OFFICIAL NOTICE OF DECISION

CITY OF ALBUQUERQUE
PLANNING DEPARTMENT
DEVELOPMENT REVIEW BOARD

5. Project # 1005182

WILSON AND CO. agent(s) for LA CUENTISTA II, LLC request(s) the above action(s) for all or a portion of Tract(s) C, correction plat of the bulk land plat of La Cuentista Subdivision (to be known as **LA CUENTISTA SUBDIVISION, UNIT 2**) zoned SU-2/SRSL, located on ROSA PARKS RD NW, between ALOE RD NW and KIMMICK DR NW containing approximately 36 acre(s). [REF: 06DRB01428] [*Deferred from 1/17/07 & 1/24/07*] (C-10/C-11)

**AMENDED PRELIMINARY PLAT
LA CUENTISTA SUBDIVISION, UNIT II**

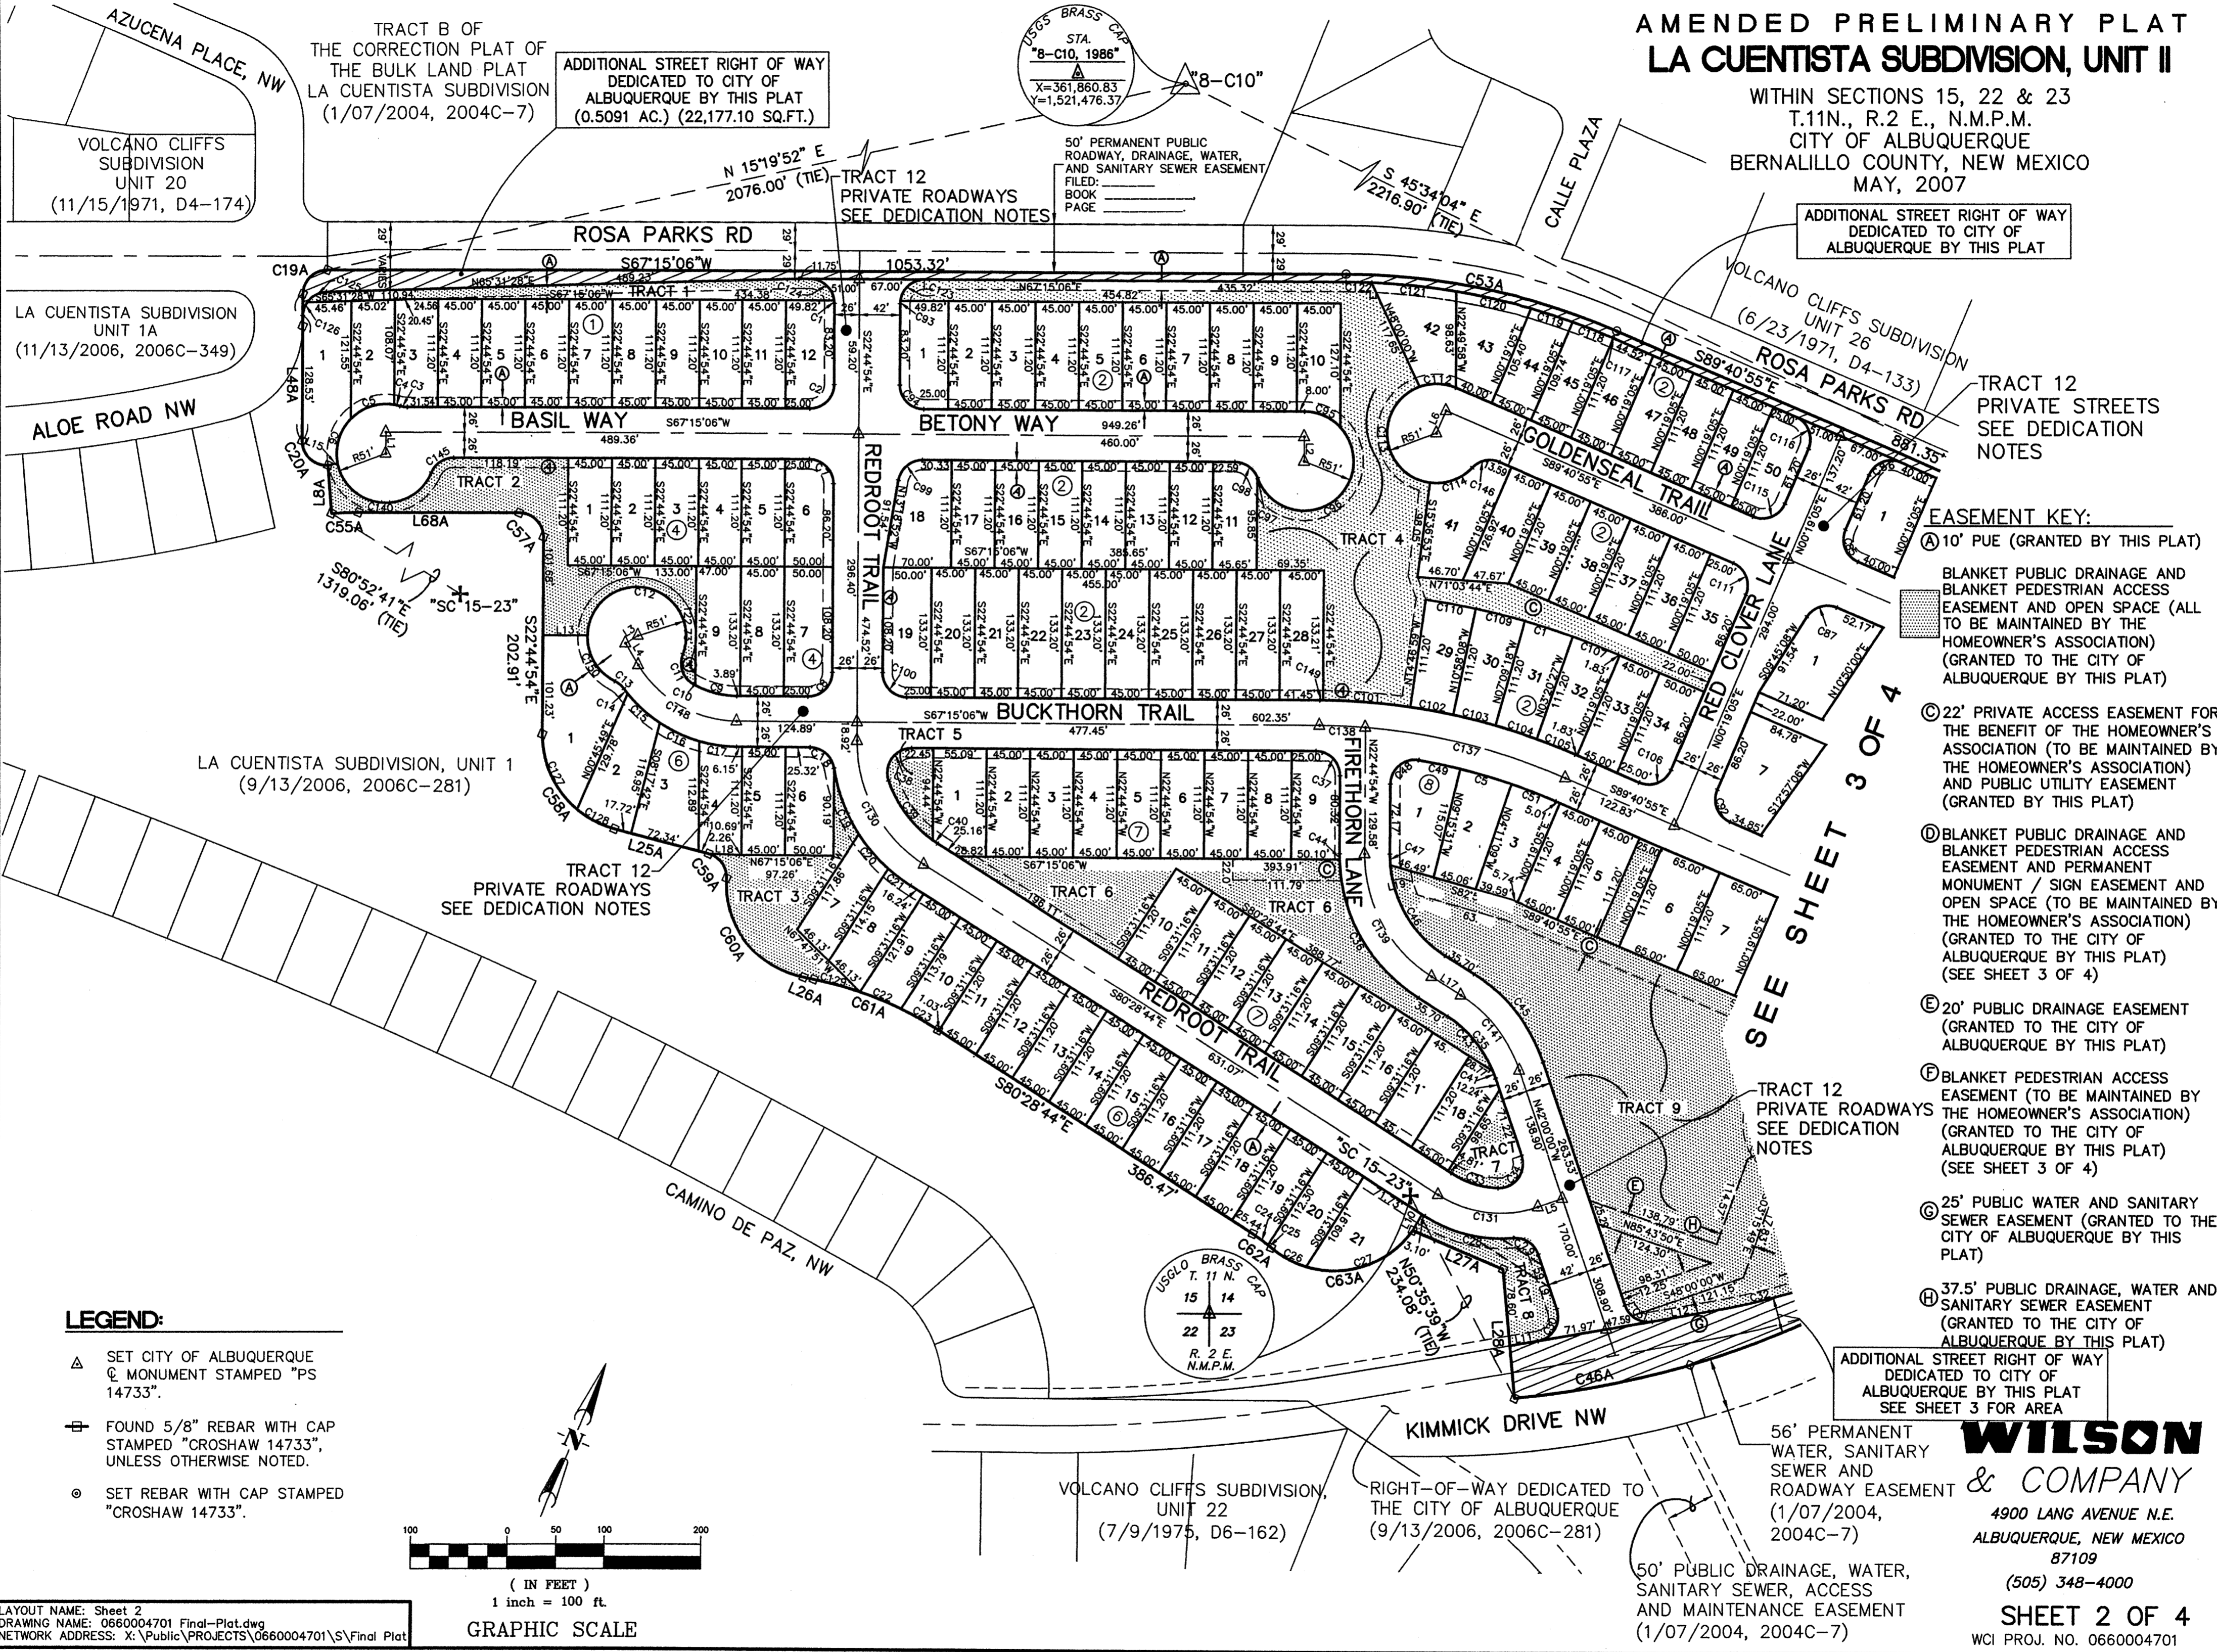
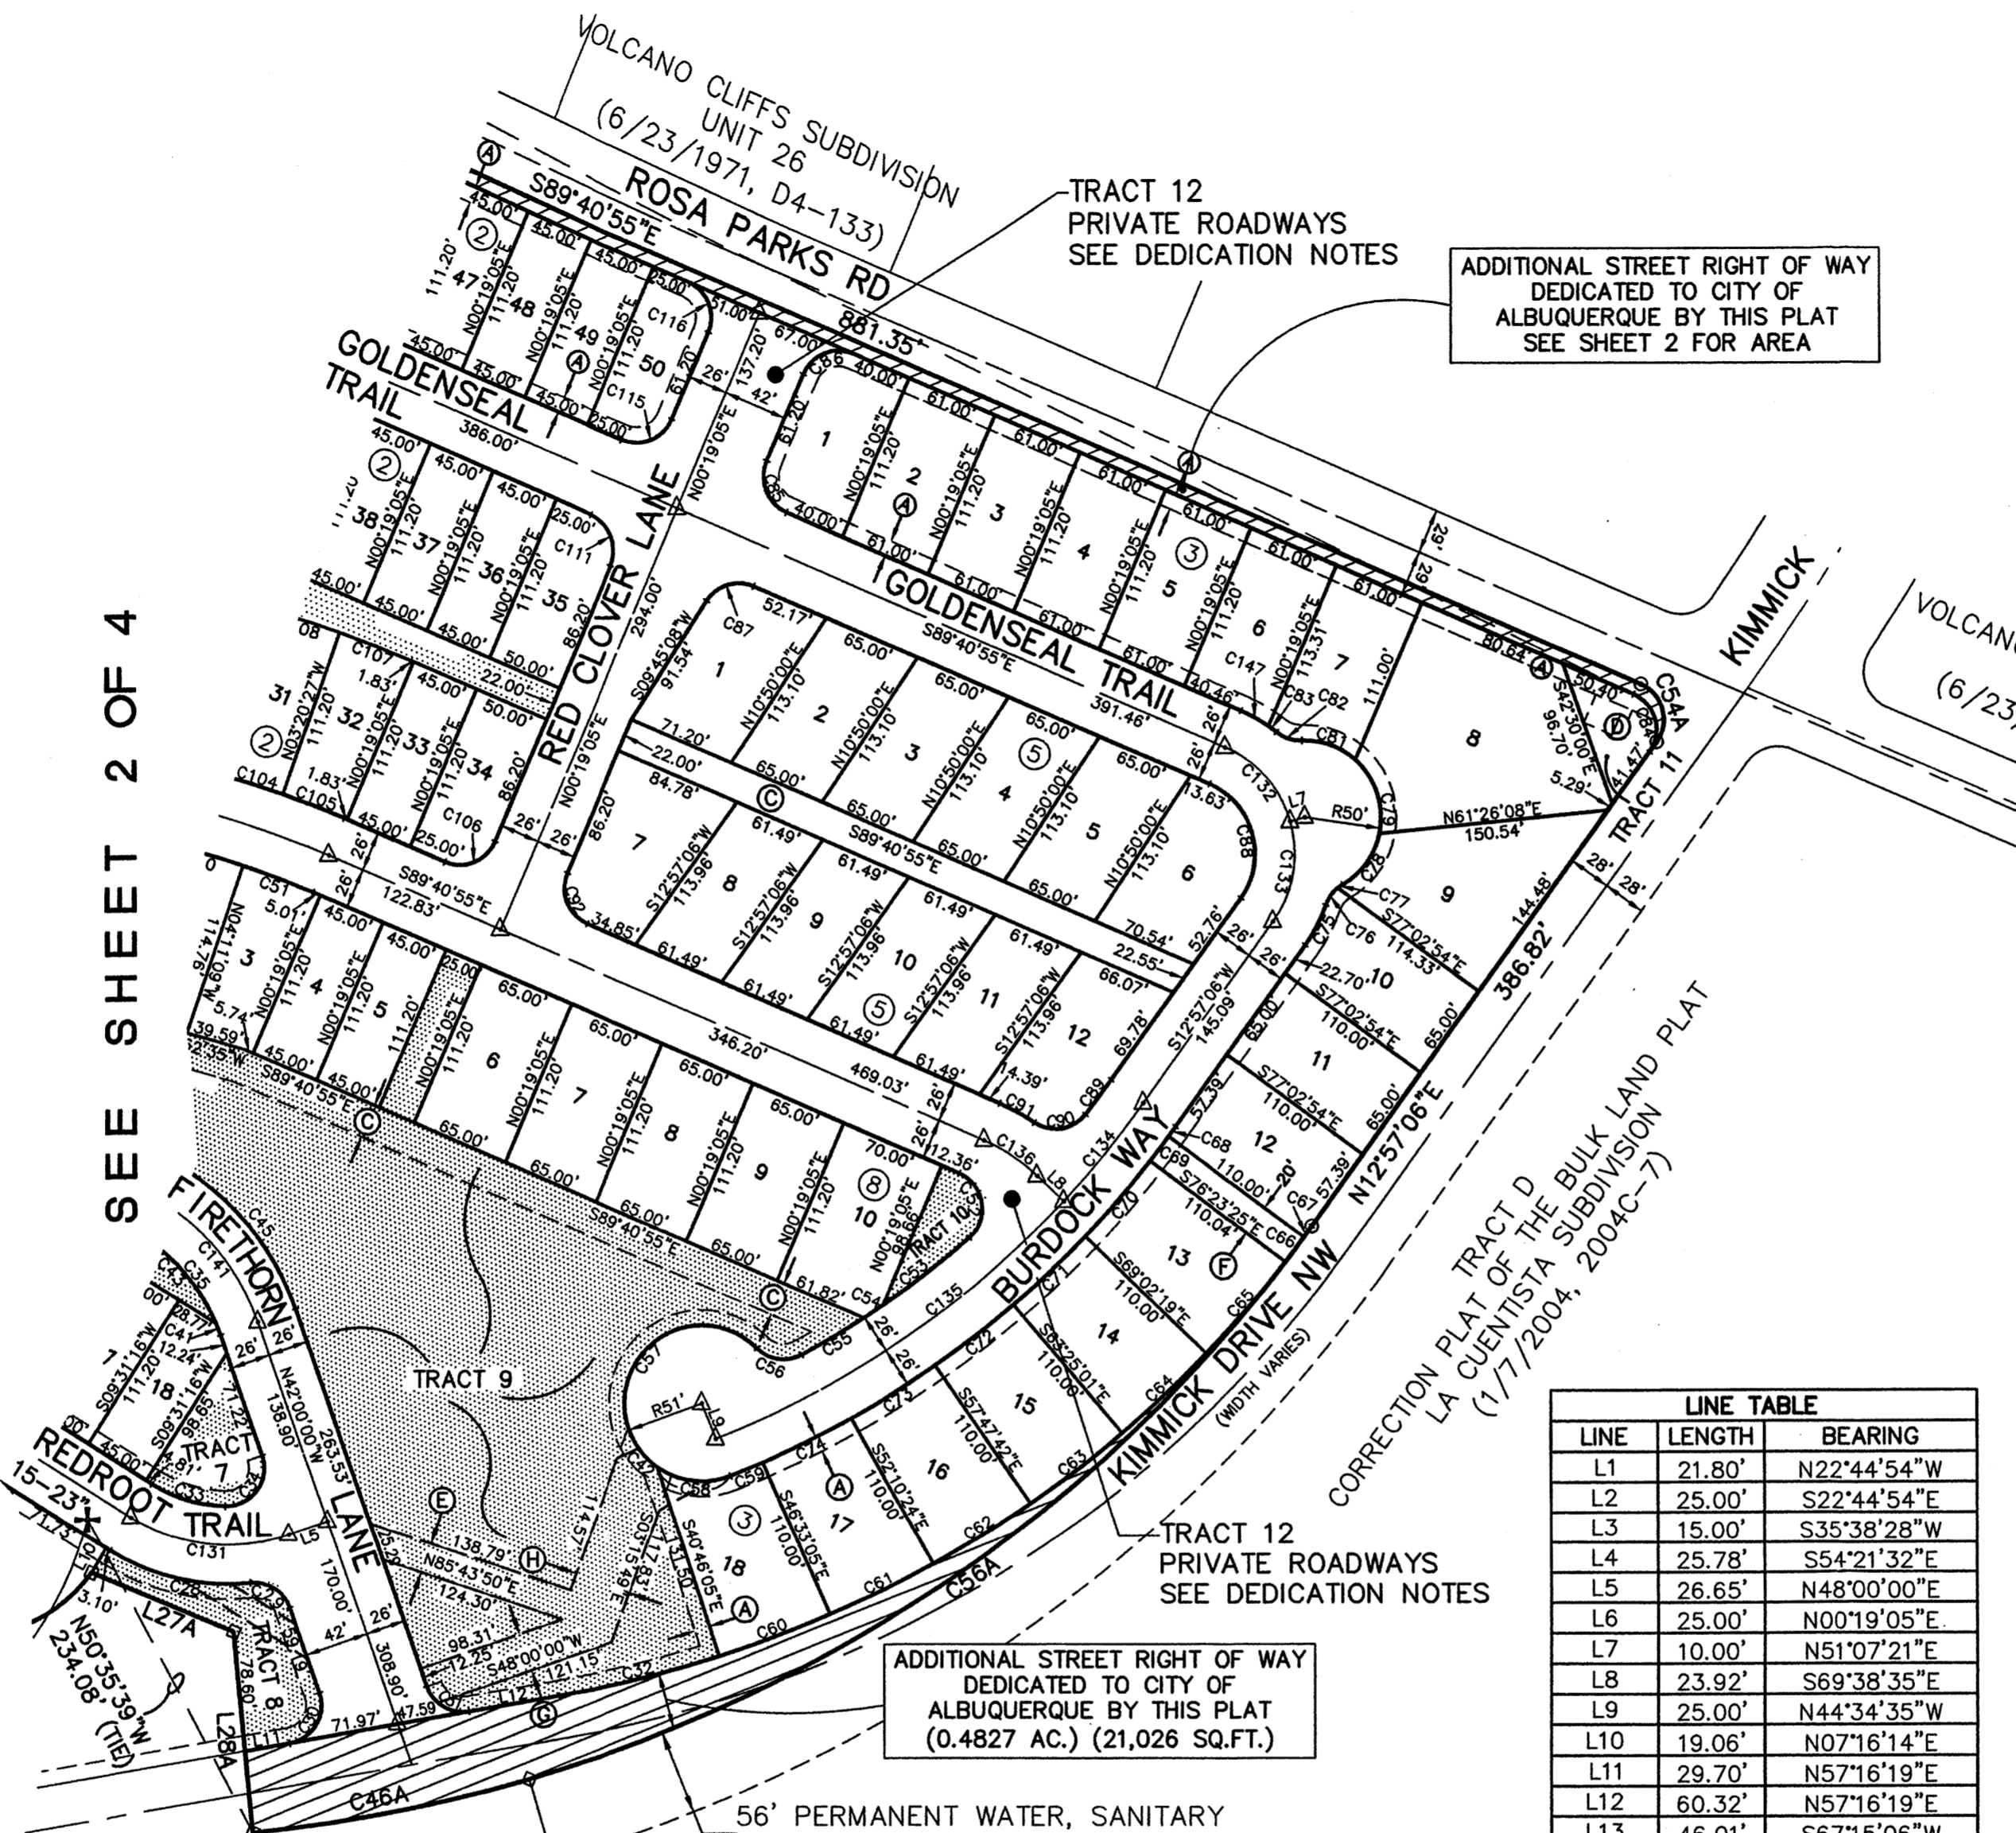
Revise gate quequing analysis.

Re-evaluate right-of-way widths at entrances of subdivision.
